From: Richard Temple
Sent: 14 February 2018 15:23
To: Karen Parsons
Subject: FW: Ref Planning Application FP/268/17/PL update

From: Roger Spencer
Sent: 12 February 2018 11:35
To: Richard Temple
Subject: FW: Ref Planning Application FP/268/17/PL

Subject: Ref Planning Application FP/268/17/PL

Timber Planks to be fixed without gaps, to the timber posts, sitting on top of the existing seawall.

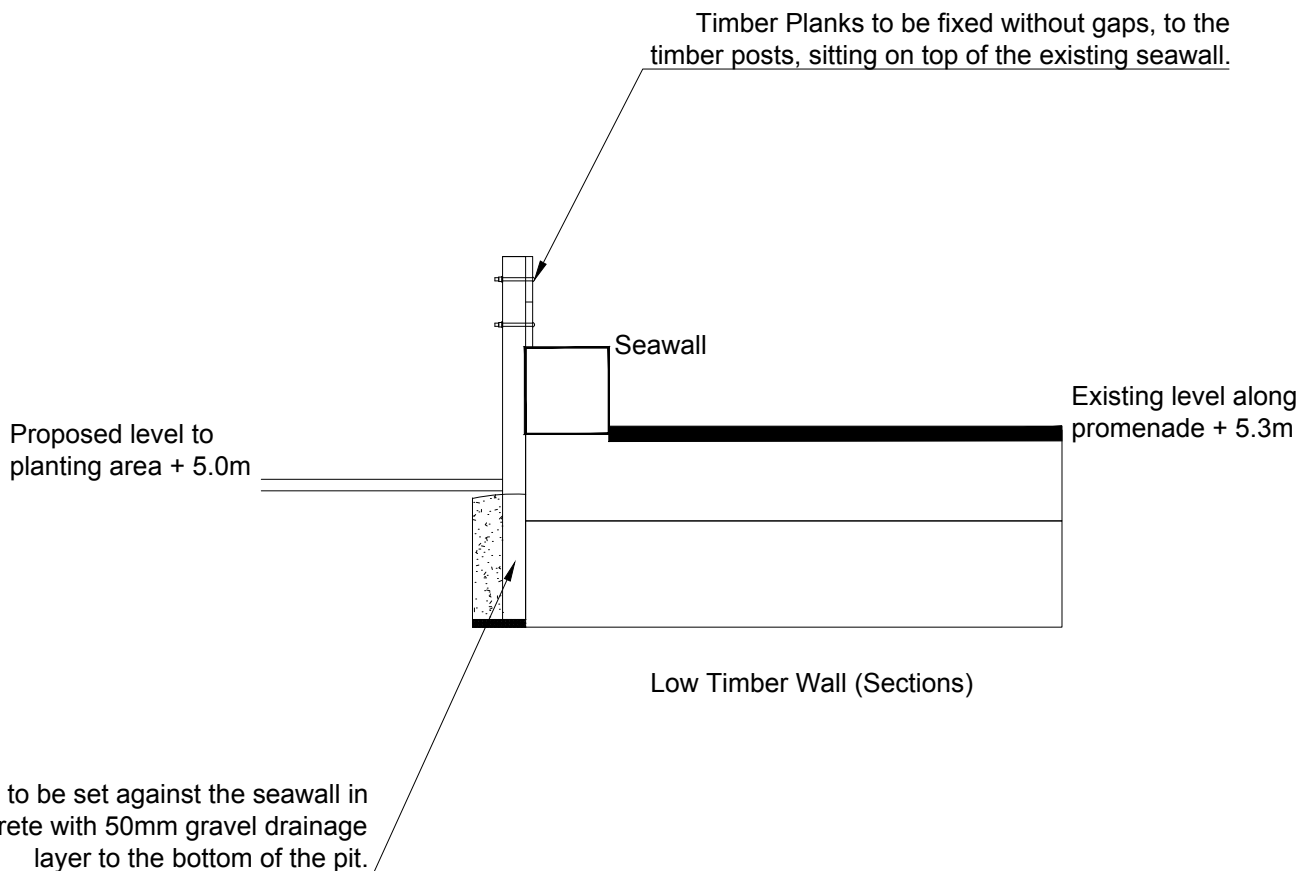
Thank you for turning round my comments -- what you have shown on your Drg LLD1268-LAN-DWG-400 is more to my way of thinking.

I note that you have shown 2 No. 300mm high (x 50mm wide) planks to make up that 600mm. The 300mm width is not usually an economic section -- it may be worth considering 3 x 230mm (9") -- this would necessitate the post to be raised slightly to support the extra 90mm?? However, I consider either (600mm or 690mm above the rear splash-wall) to be reasonable.

However, I would urge you to change the min 1500mm centres to "max"

I would also suggest that you reconsider the fixing detail. As it stands, with the fence tight up against the back of the seawall, you wouldn't be able to fix the planks to the posts - suggest that you fix the posts against the wall then start the planks on top of the wall. You may have considered that we

wouldn't like this encroachment over the seawall but I think it is preferable to your current detail. Sitting the bottom plank on top of the wall would also provide for a better seal too.

I assume that you'd concrete the posts into the ground, as I wouldn't want to put more loading onto our seawall by fixing into the back of it. Please also consider that digging out for the concreting in may be a little problematic – I'm not sure what the construction would have been in the 1960s when the seawall went in.

Further to your last e-mail, please find attached drawing detailing the low timber wall running behind the existing promenade wall, as noted on the landscaping drawing.

- Made of sustainably sourced hardwood, ideally matching the material used for timber groynes located adjacent to the site.
- Posts to be min. 150x150x2400mm set at min. 1500mm centres.
- Timber Boards / Planks to be min. 50mm thick, length to match layout of the posts.
- All of the dimensions and specifications to be confirmed by the engineer.
